**Consultation Response from KC,
Lead Local Flood Authority**

2023/90237 Park Gear Works, Park Road, Lockwood, Huddersfield, HD4 5DD

Discharge of condition 10 (drainage strategy) of previous permission 2020/91894 for demolition of existing building and erection of engineering building with associated external works

Date Responded: 15/06/2023.

Drawn: P.A.S. Checked: S.A.B. Date: Aug 2020 Scale: 1:200 Original Issue No: AO
 Drawing Name: DBS-AVE-00-XX-DR-C-0001 No: C17

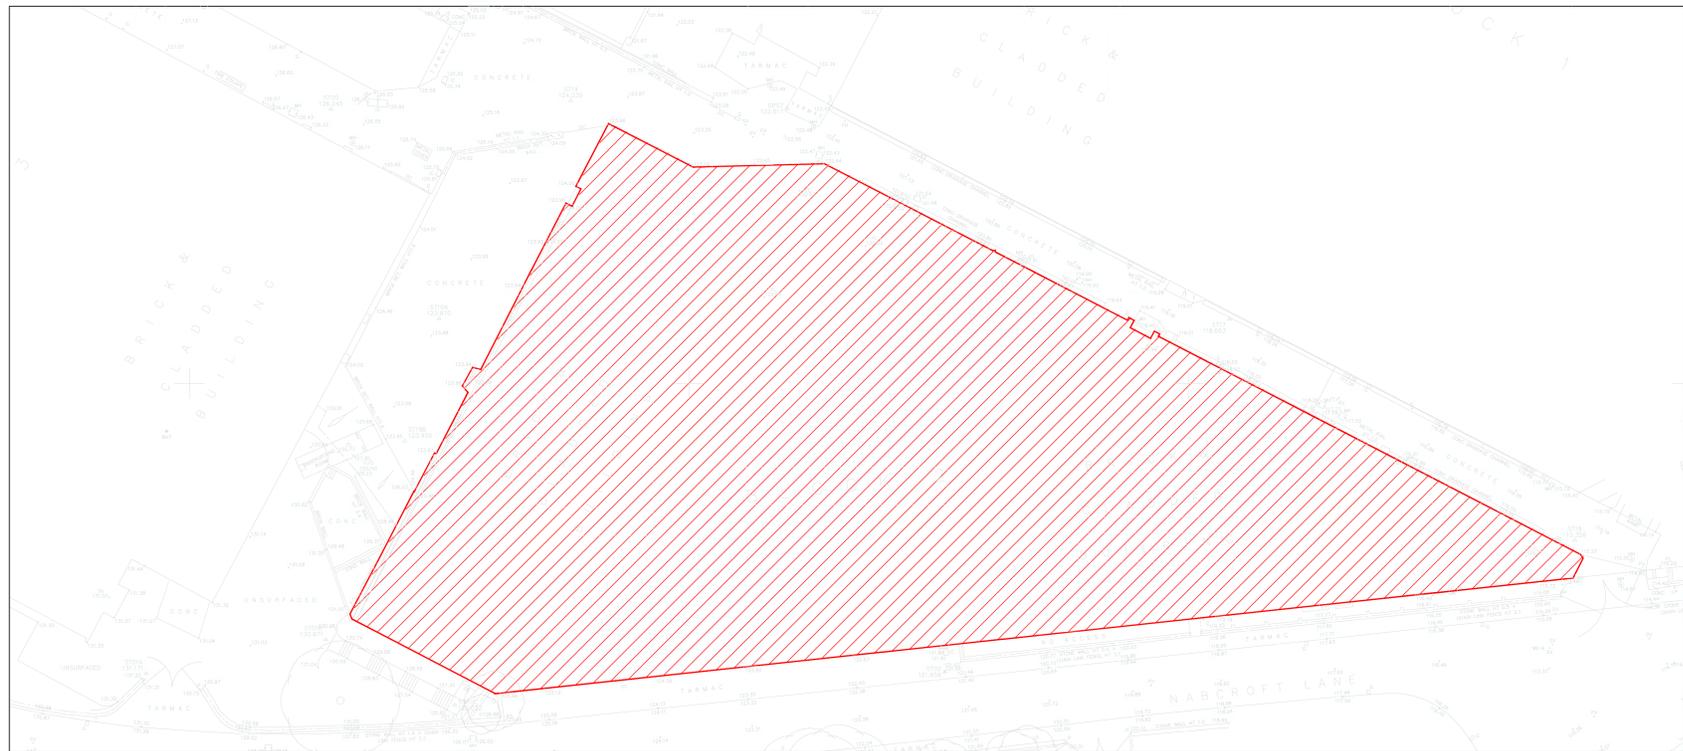
The hydraulic calculations indicate a 40m³ attenuation storage tank (50m² x 0.8m), however this is not indicated on the Drainage Layout drawing. It is assumed DBS 3 is MH S09, although the IL shown on the drawing is different to that in the calculations for the HydroBrake.
